#### SUBMISSION

#### HUNTER VALLEY OPERATIONS – ENVIRONMENTAL IMPACT STATEMENT

HVO NORTH OPEN CUT COAL CONTINUATION PROJECT

HVO SOUTH OPEN CUT COAL CONTINUATION PROJECT

Figure 1 Sensitive receptors

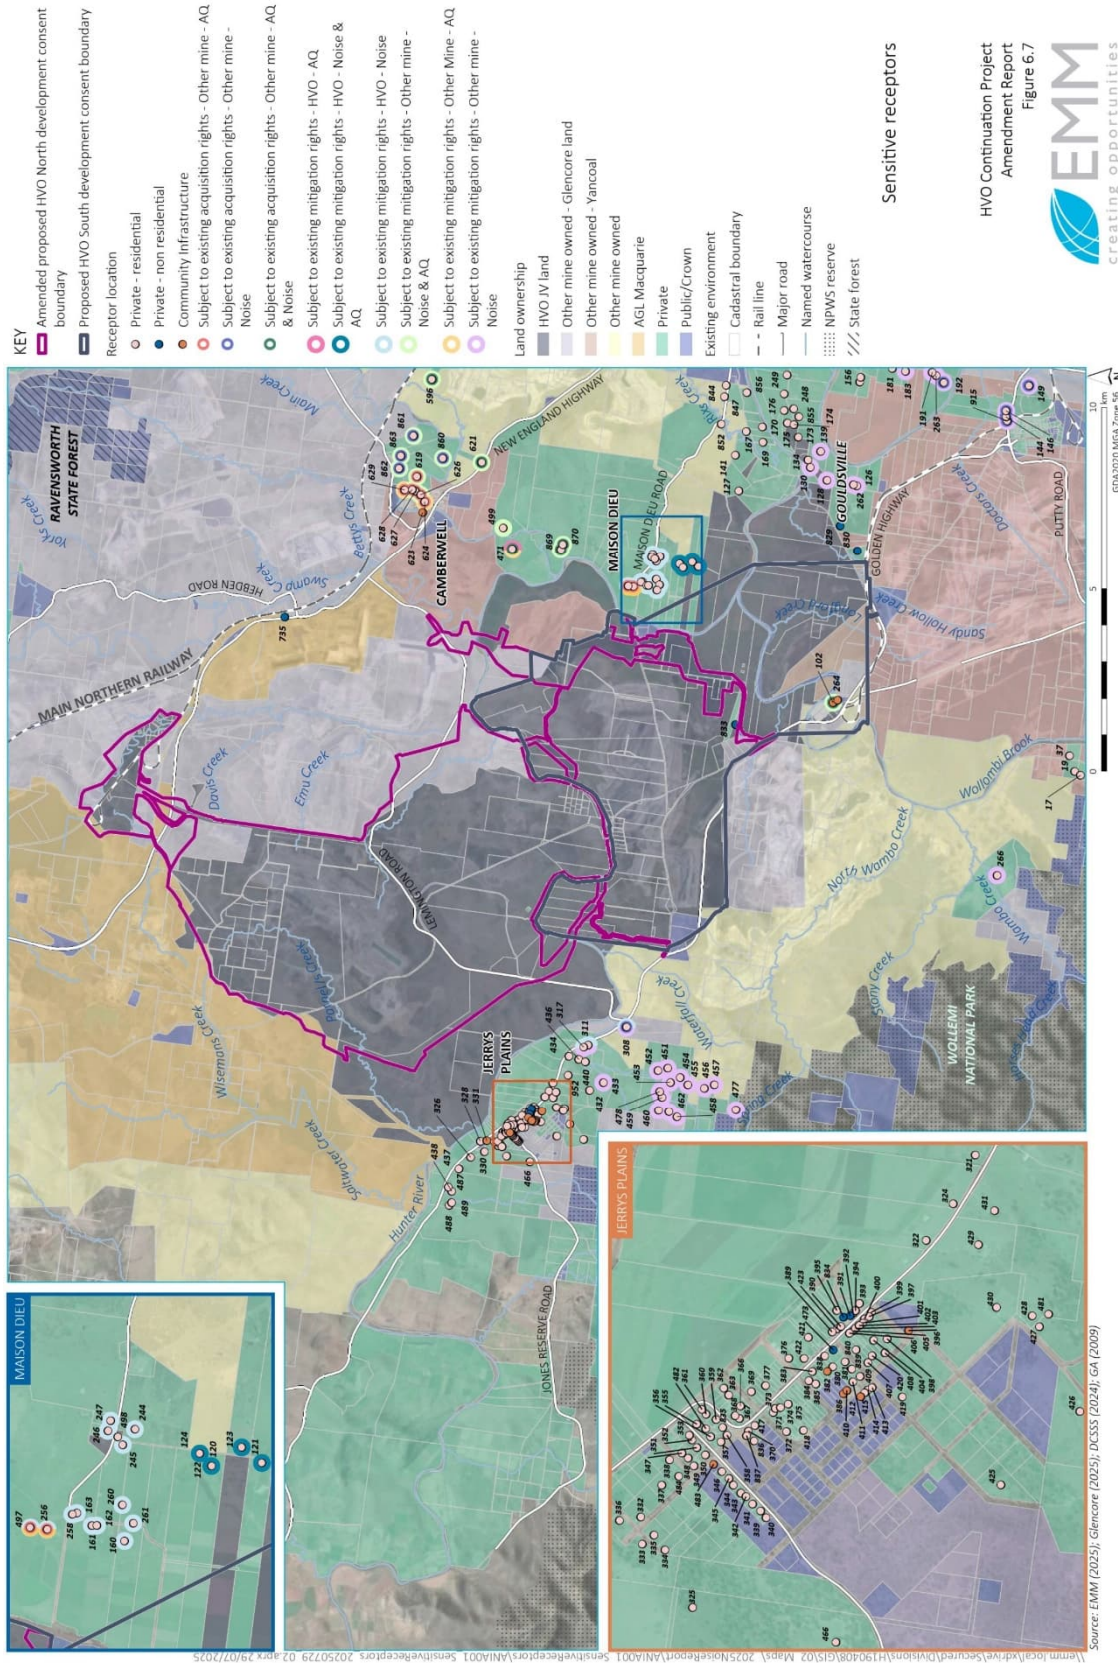
The HVO EIS identifies a property in Jerrys Plains (receptor 308) that, as a result of this project, will have increased air quality impact risks and has been identified and earmarked as qualifying for air quality acquisition rights. It should be noted that this is an indicator of the potential impacts on Coolmore.

Jerrys Plains sensitive receptors R308 and R321 are now predicted to be impacted by fine particles (PM<sub>10</sub> and PM<sub>2.5</sub>) with a peak at Year 11 of the Project. These receptors now qualify for the VLAMP acquisition criterion. (Refer Table 8-4 EIS). Can HVO advise why the Project’s dust emissions and impacts cannot be managed for 11 years given the significant impact this will have on neighbouring properties including our own?
